Application No: AB/6/25/PL
Site Address: Sparks Yard 18 Tarrant Street Arundel BN18 9DJ
Description of works: Conversion of existing single residential unit with associated commercial space to form 3 No. residential units together with associated works and rear/side extension. This application affects the setting of listed building, affects the character and appearance of the Arundel Conservation Area, is in CIL Zone 2 and is CIL Liable as new flats.

Thank you for your internet representation made on 3rd February 2025 which has been recorded as an objection with the comments as follows:

**PARTLY  
IMPLEMENTED AND  
PROPOSED SOUTH  
AND NORTH  
ELEVATIONS**  
A6010 108  
1 : 100 @ A1  
01.01.25

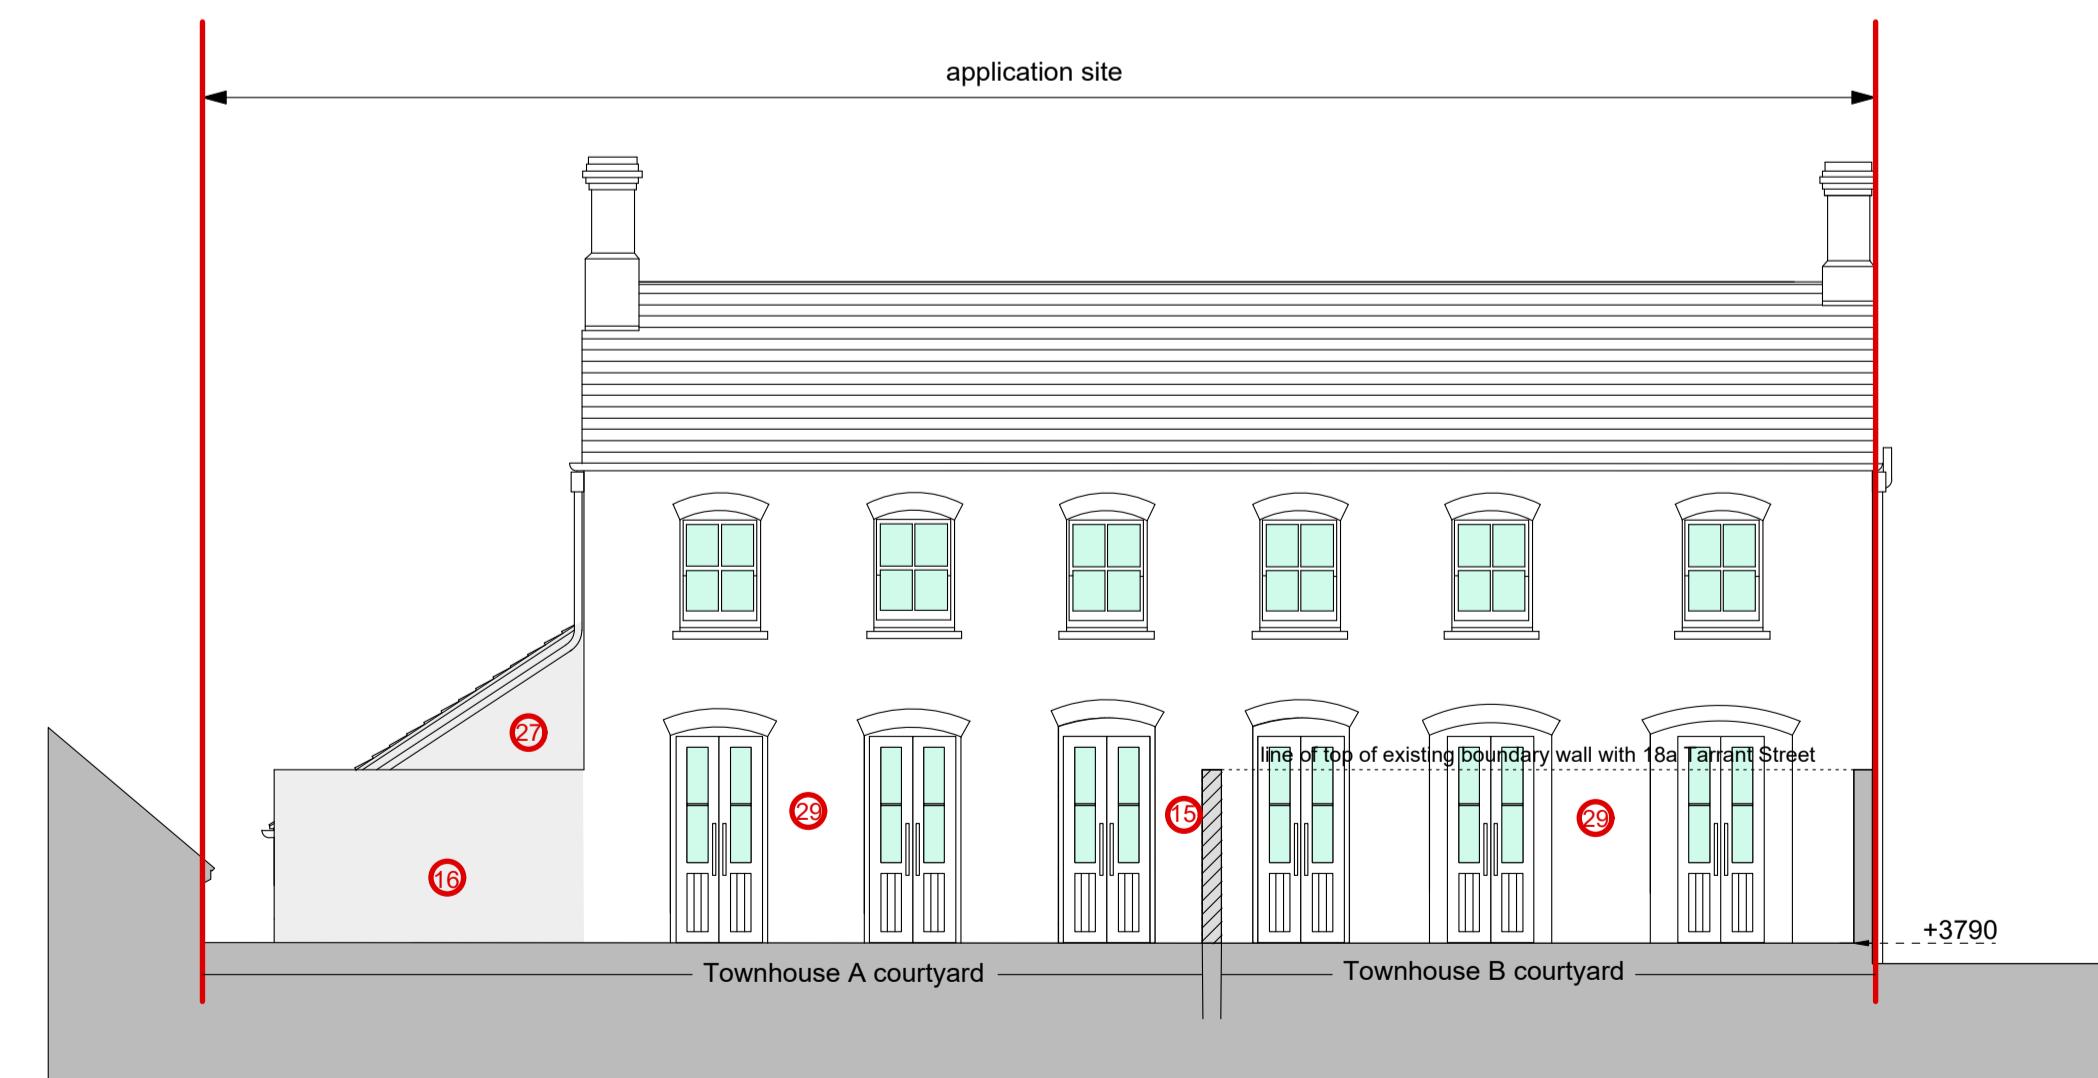
The Planning Committee objected on the grounds that the third small unit results in over development of the site and that any use of obscured glazing for bathrooms on the front elevation would be wholly inappropriate and have an adverse effect on the character and appearance of the building.
